Your Ref: OWPC4633
Our Ref: LU/324/14/PL 15-10-2014
Please ask for:
Mrs A Gardner

Change of use of residential institution (C2 Residential Institutions) to form 3 No 2
bedroom flats (C3 Dwelling Houses) (resubmission following LU/207/14/PL)
13 Fitzalan Road Littlehampton

SITE PLAN

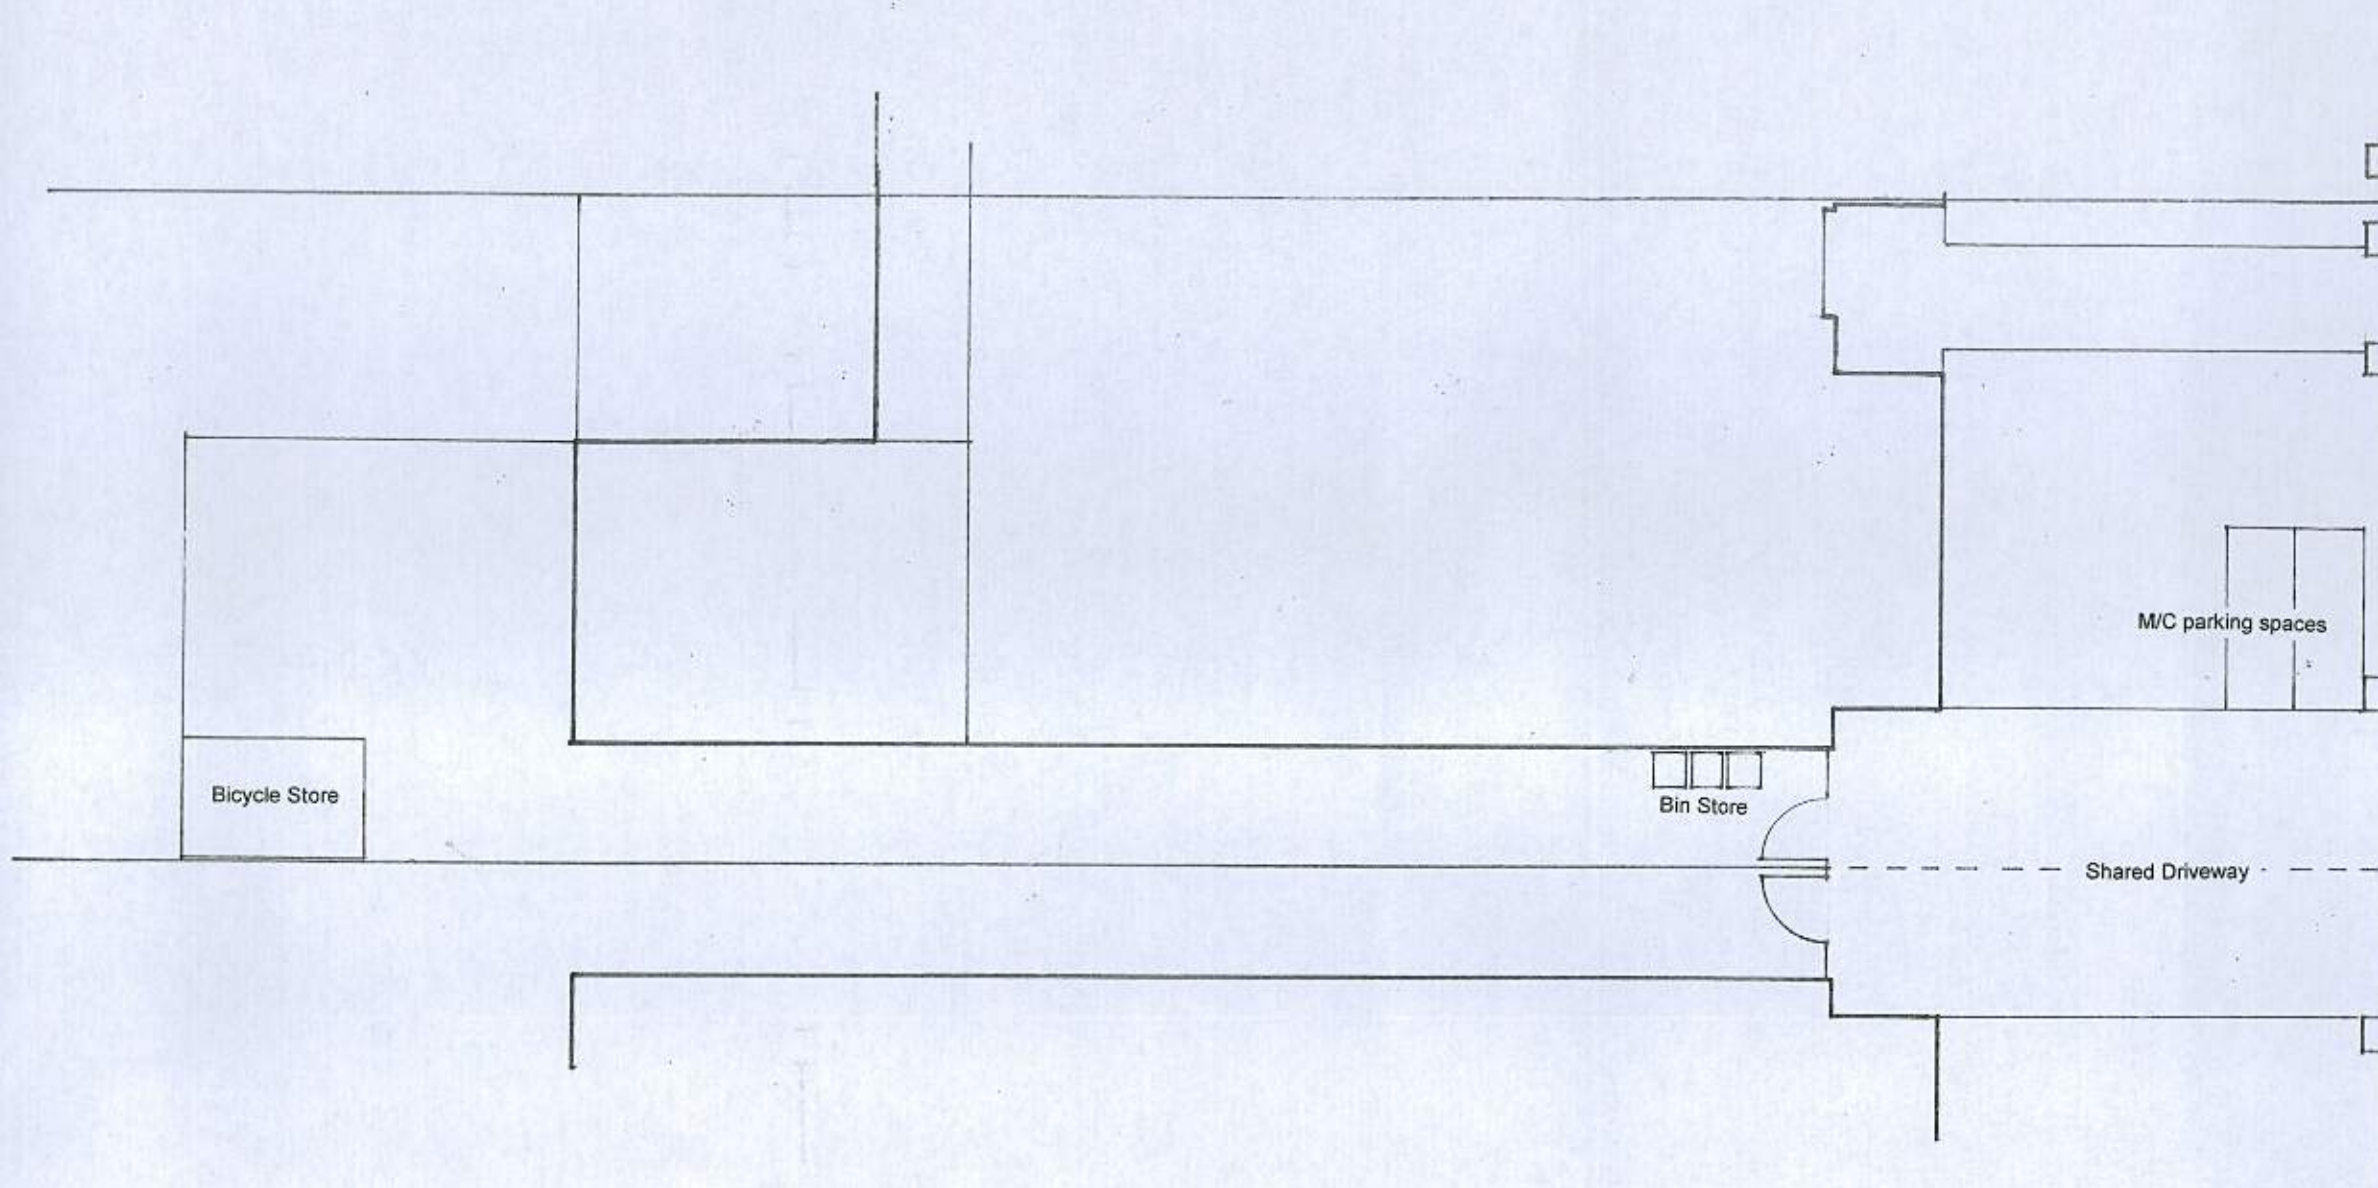
Secondly, there is insufficient parking to support the development. Jamie Barber states that there is vehicular access to the property, which is not the case. the shared driveway does not allow access to number 13 without the agreement of the owners of number 12, as that property (number 13) has no parking space which would not impede access to the parking at number 12. Parking is regularly an issue in this road, especially during the summer months. Off-road parking is the only way residents can guarantee being able to park near to their property. We would at very least like the opportunity to discuss with the owner the erection of a wall to divide the drive and the creation on either side of separate drives. Without this, there is no private parking at number 13, where it is likely that the 3 proposed flats would attract up to 6 cars.
